From: Zac Denton
Sent: 12 November 2018 14:47
To: Planning.Responses
Subject: FW: LU-235-18-PL - Environmental Health Consultation

Please see plan and relevant room spec for the proposed change from partial residential partial guest house to fully residential as House in Multiple Occupation (HMO).

The application is at 36 Pier Road, Littlehampton.

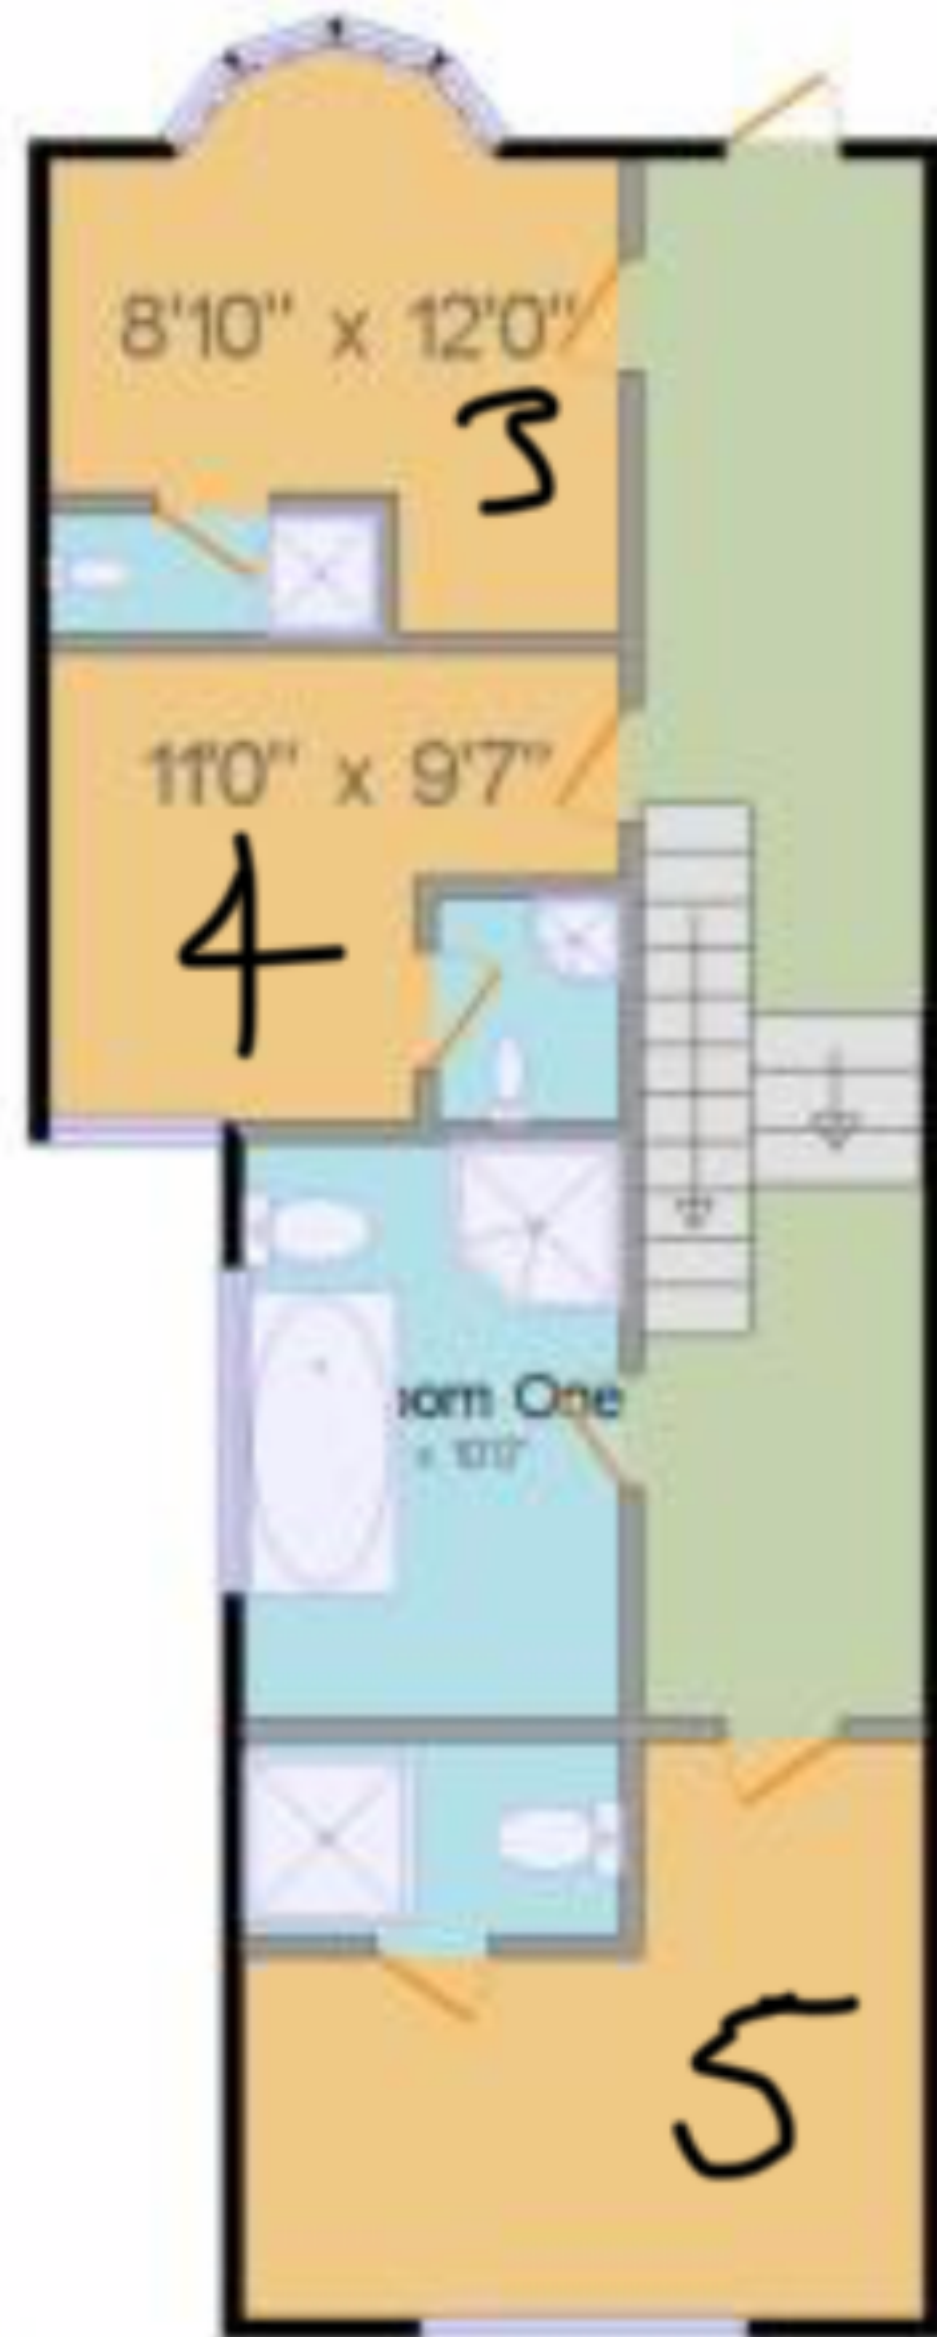
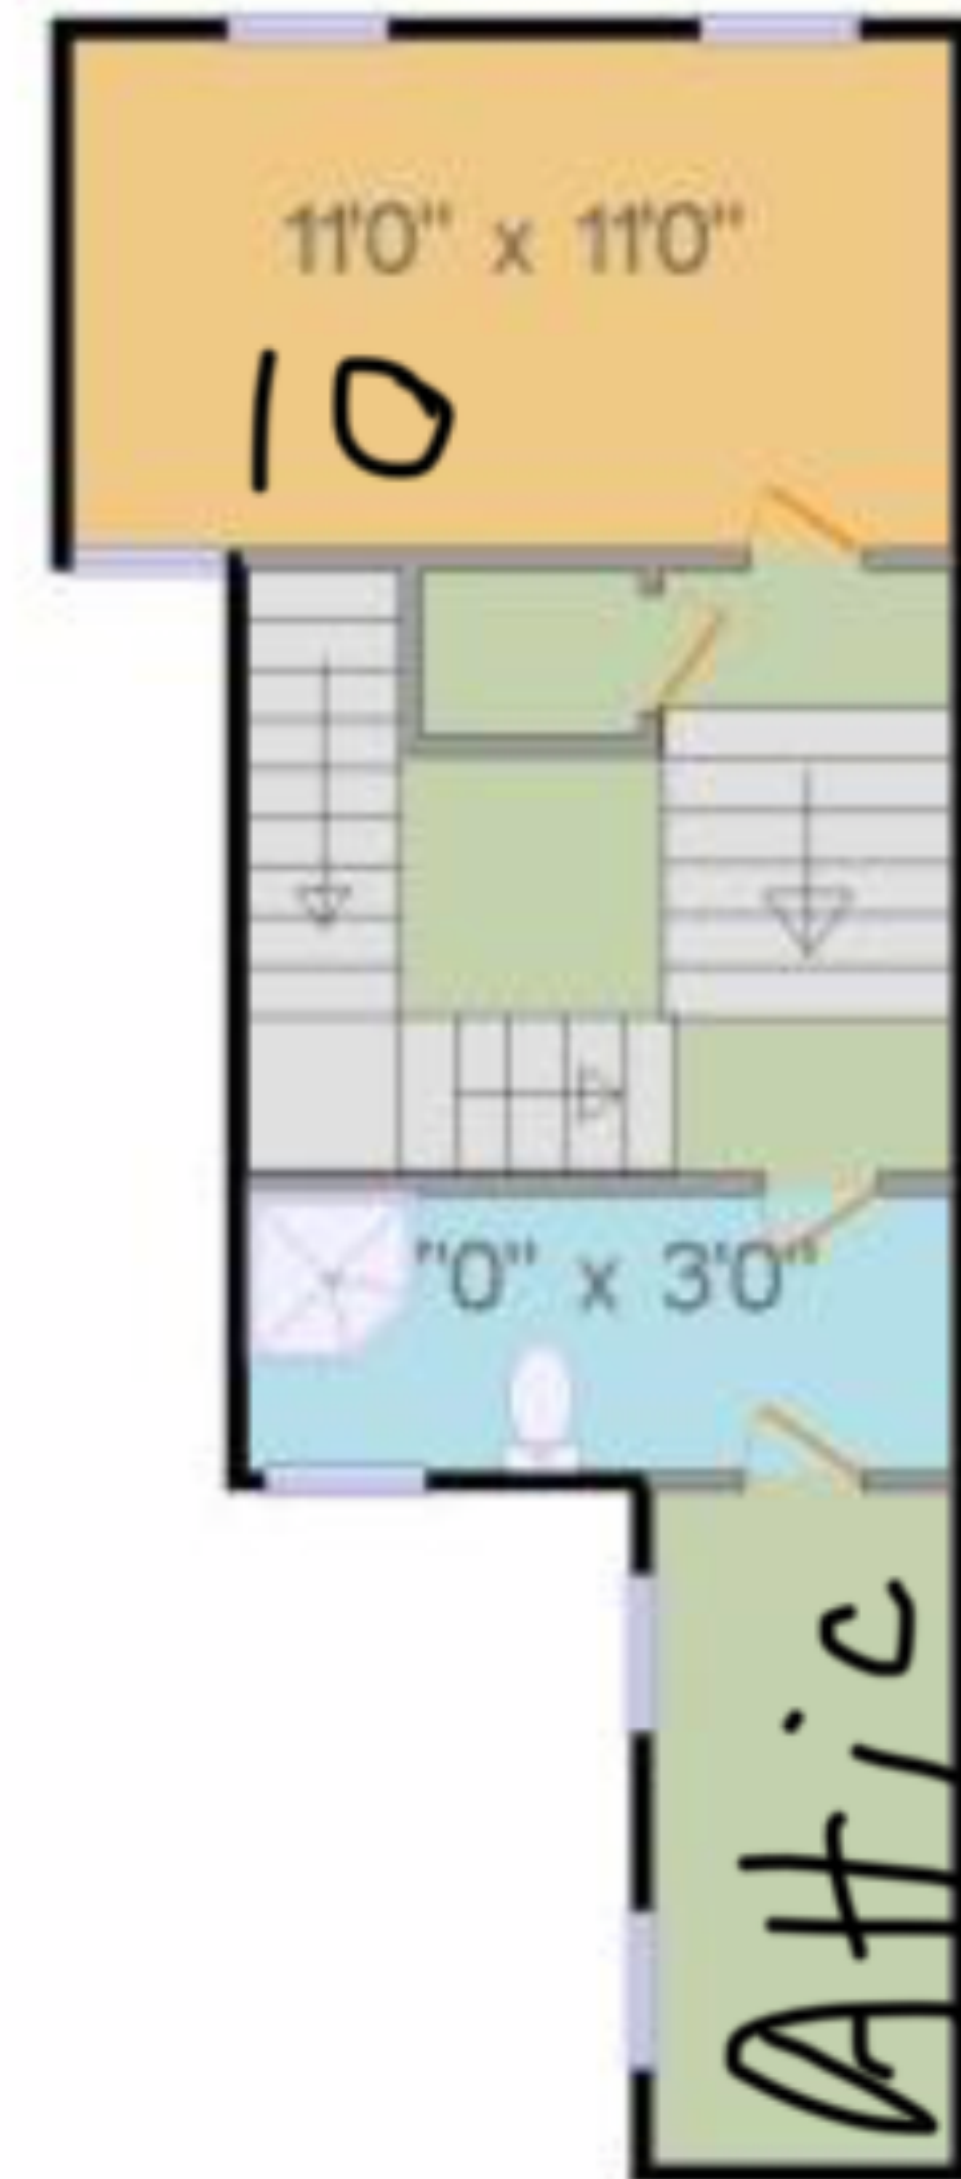
Room Sizes - In respect of this application specifically, it is considered that due to the size of the kitchen and dining room, the bedrooms are of sufficient size to be occupied by one person per room, except Room 9, which is only of sufficient size for a child. If a (fire) door were provided between the hallway and the bedroom this could be used as a single unit for a parent and one child up to the age of 10 years old.
